Consultation Response from KC Conservation and Design
2019/92962 Field House, 15 , Wellington Road, Dewsbury, WF13 1BQ
Erection of additional storey and conversion of building to provide 23 self-contained apartments and A3 use in basement and part of ground floor (Listed Building within a Conservation Area)
Date Responded:
Responding Officer: NH
Responding Ref: DM 7/98

TITLE  
PROPOSED ELEVATIONS

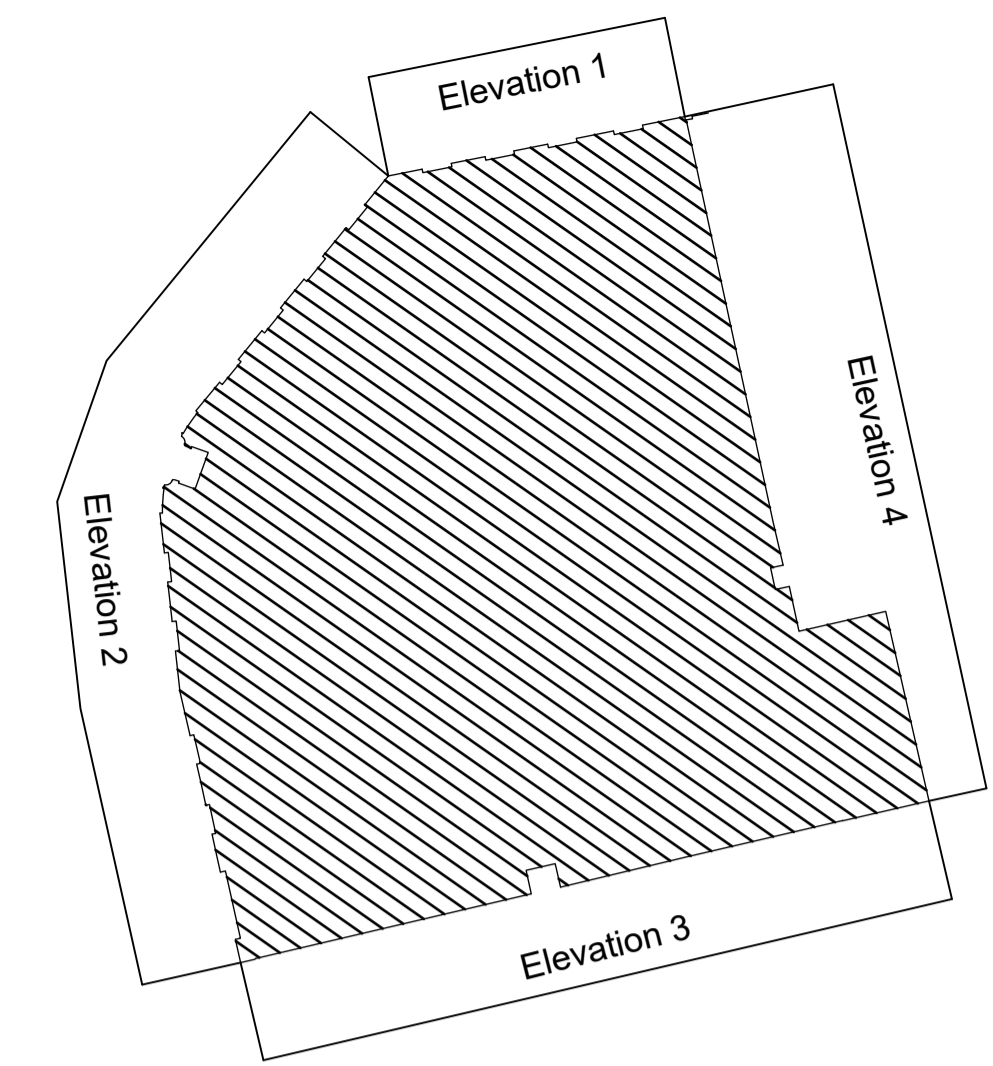
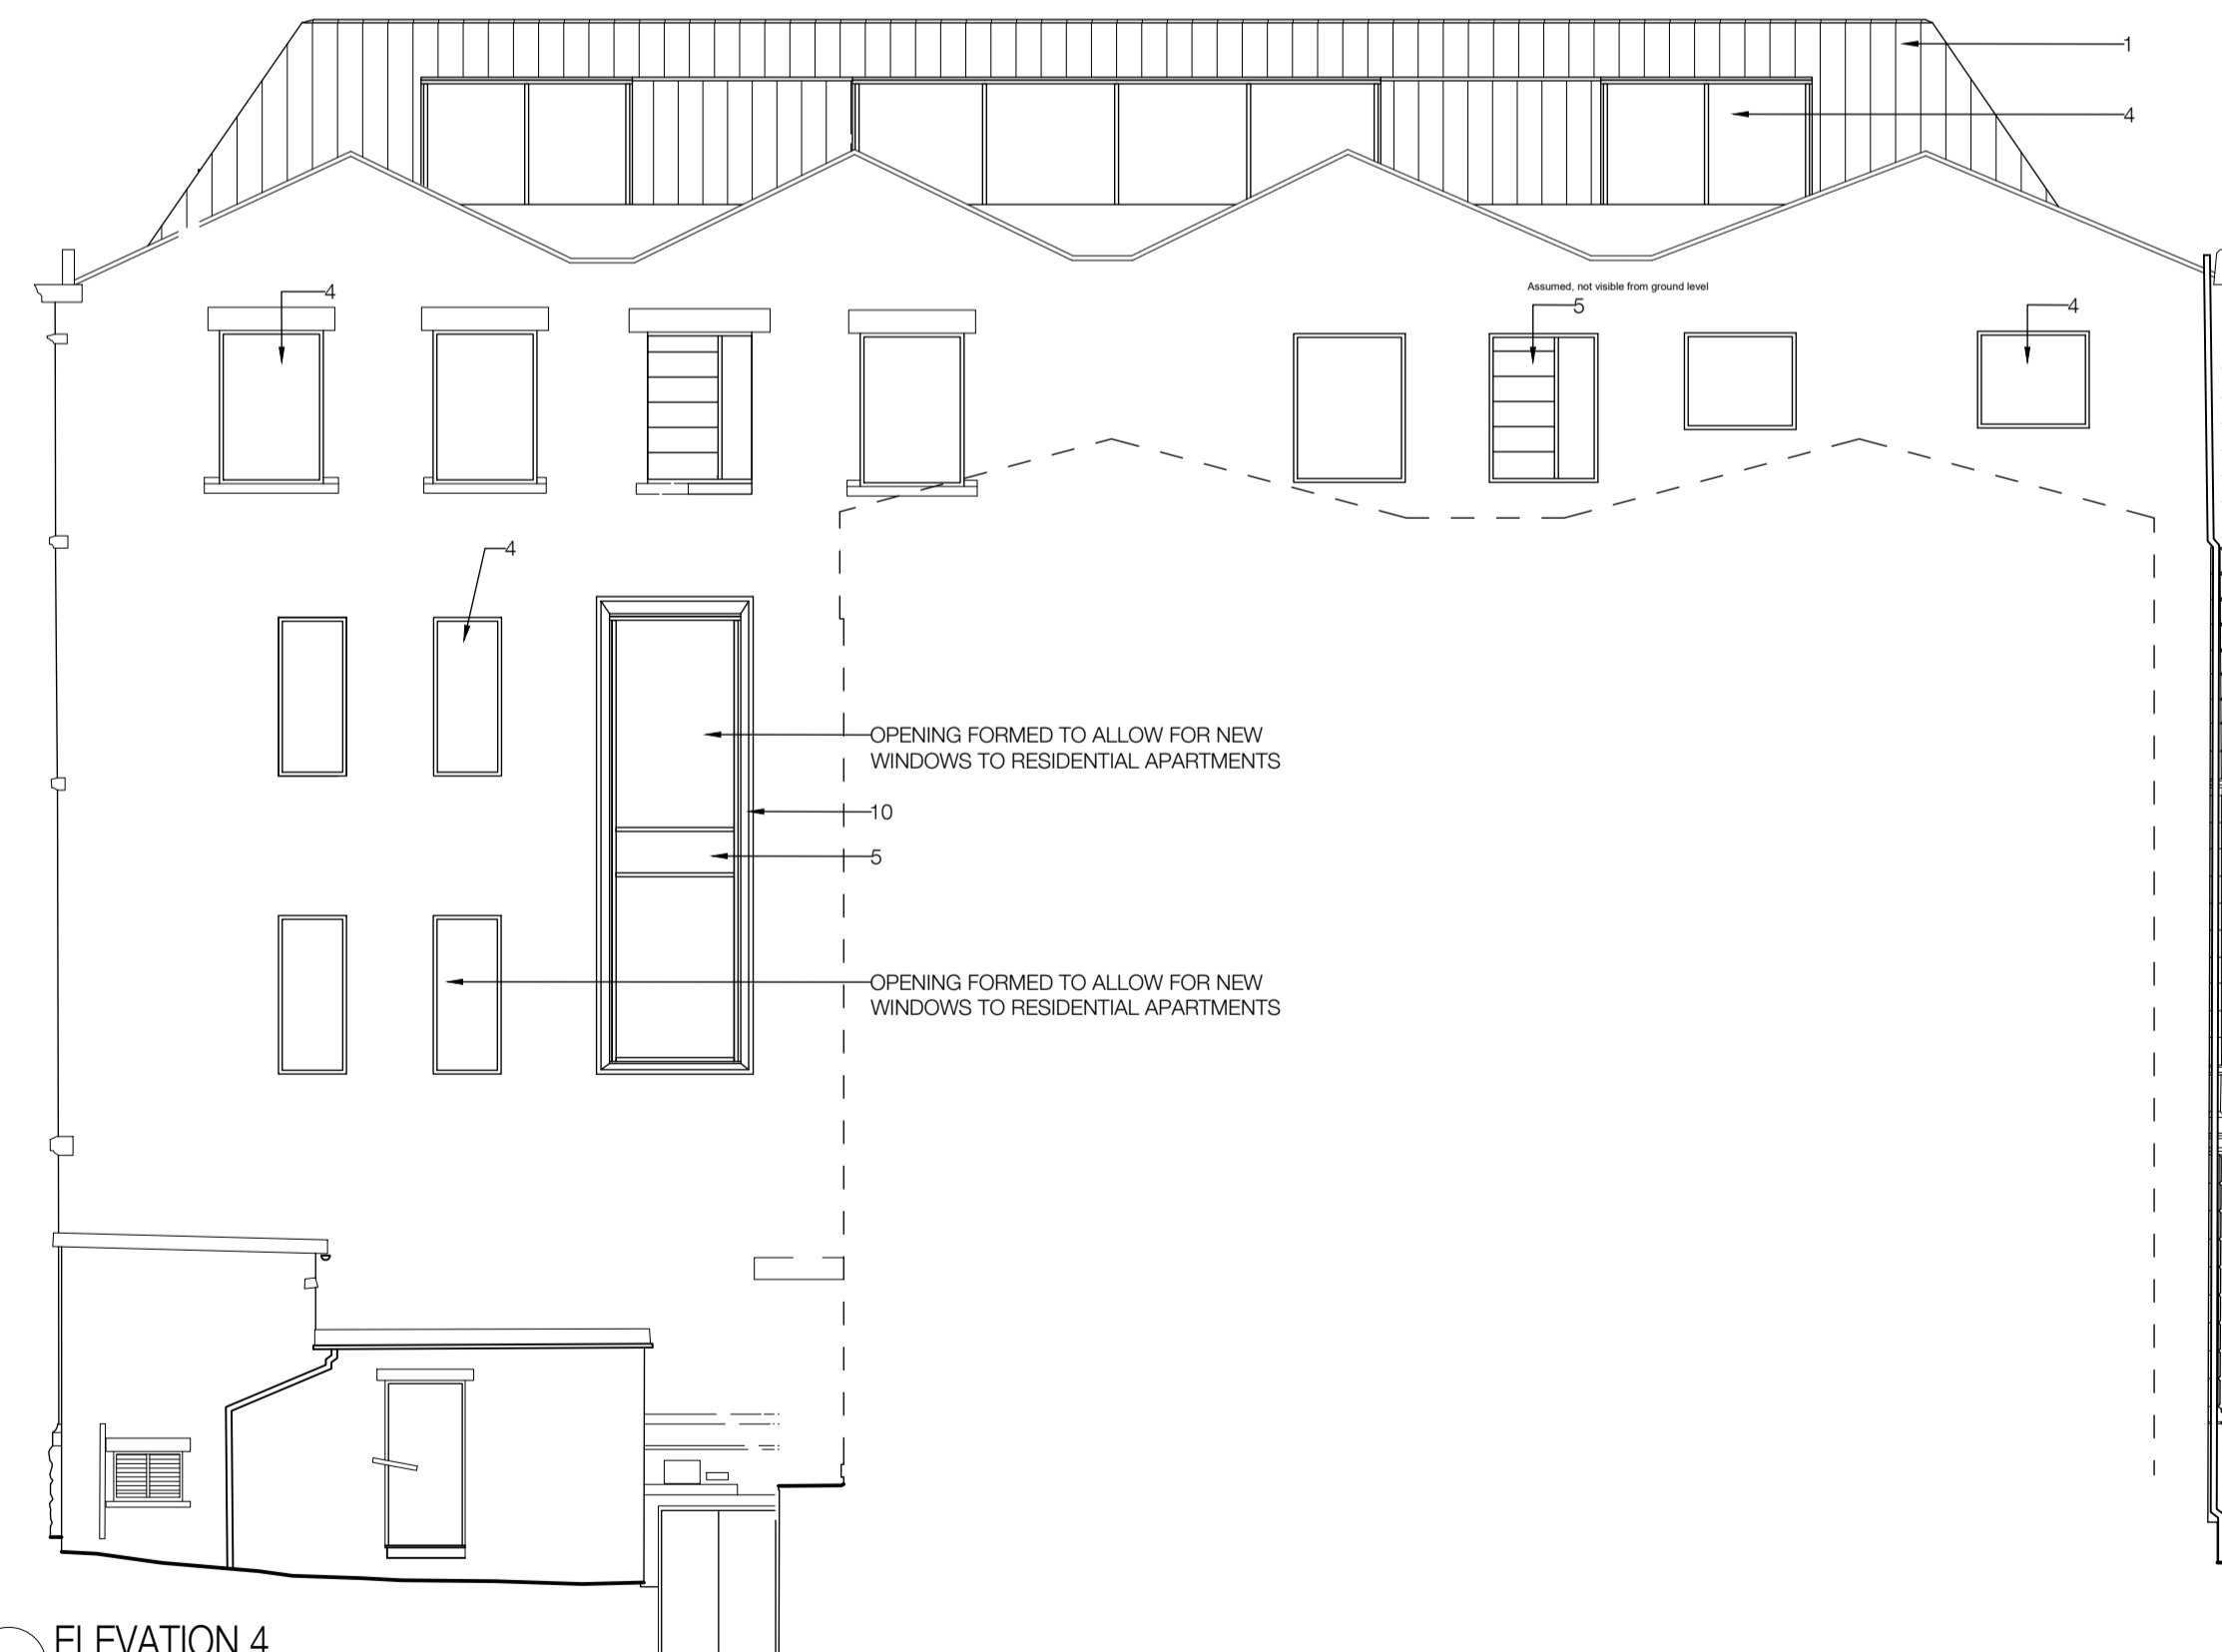
The application suggests that the alteration to the roof will not harm the significance of the conservation area or the appearance of the listed building. The Heritage Impact Assessment goes as far to state: “As no harm to the listed building or conservation area has been identified, the proposal does not engage either paragraphs 195 or 196 of the NPPF.” I have to say I cannot agree to this statement. The alterations will provide for a change in roof style and insert a feature that does not appear within this part of the conservation area. This part of the conservation area, based upon the character of the other buildings along Wellington Street, is typified by a consistent approach to the design of the buildings in terms of overall design, proportion, consistent roof profiles and consistent eaves lines. This is stated in the conservation area appraisal. Therefore how possibly can there be no harm when these principles of significance are broken by this proposal?

There is harm and in my opinion this is undeniable but the main issue that follows is what level of harm this is when assessed against the requirements of the NPPF. Paragraph 193 states that great weight should be given to the assets conservation irrespective of whether potential harm amounts to substantial, total loss or less than significant harm. Paragraph 194 further suggests that any harm to the significance of the heritage asset should require clear and convincing justification. The application is supported by two thorough documents, the Design and Access Statement and a Heritage Statement and whilst I disagree with the conclusions of the latter document it does describe the significance of the building well. The D&A does provide details of the number of iterations the scheme has gone through to come to this design and this is welcomed as this goes towards mitigating the harm which is required before the heritage balance is applied. Paragraph 195 discusses substantial harm whereas

paragraph 196 looks at less than substantial harm. In the context of this application it is the harm to the significance of the conservation area as a whole that needs to be assessed which is stated in paragraph 201; it states that the harm should be referred back to paragraphs 195 and 196. I am of the opinion that the level of harm caused is that described in paragraph 196, less than substantial harm. Under this paragraph, such harm should be weighed against the public benefits of the proposal including securing the buildings optimum viable use (the heritage balance). The building is vacant and is in a prime location which adds to the argument that the building would act as a catalyst for the regeneration of the area. This is an answer to the conversion of the building only and not the necessity of an additional floor, in other words the conversion of an empty building should achieve this catalyst. The additional floor in my opinion is not proven in terms of securing the optimum viable use as I am not convinced from the information provided that the additional floor will add any more viability to provide a public benefit. The only way of proving that an additional floor is required to achieve this optima is by a Viability Assessment that would indicate the need for this amount of additional floorspace set against the costs of doing so, the input of any grant funding (the building is a target building of the HAZ) and the values it would bring. Without this it is not possible to balance the harm against achieving the optimum viable use. Whilst I am aware that through previous discussions there is a reticence to provide a viability assessment and judgements should be made against the regeneration benefits it brings, I am of the opinion that due to this lack of information paragraph 196 is not complied with due to the lack of proven public benefit. Equally Section 72 of the Planning (Listed Buildings and Conservation Areas) Act 1990 is failed because the proposal fails to preserve or enhance the significance of the conservation area (if para 196 was complied with then Section 72 would be as well).

In conclusion whilst the conversion is welcomed the requirement of the extra floor is not proven, and will need to be, which allows the heritage balance to be applied and to justify the need for an additional floor though a viability appraisal. Further information is required.
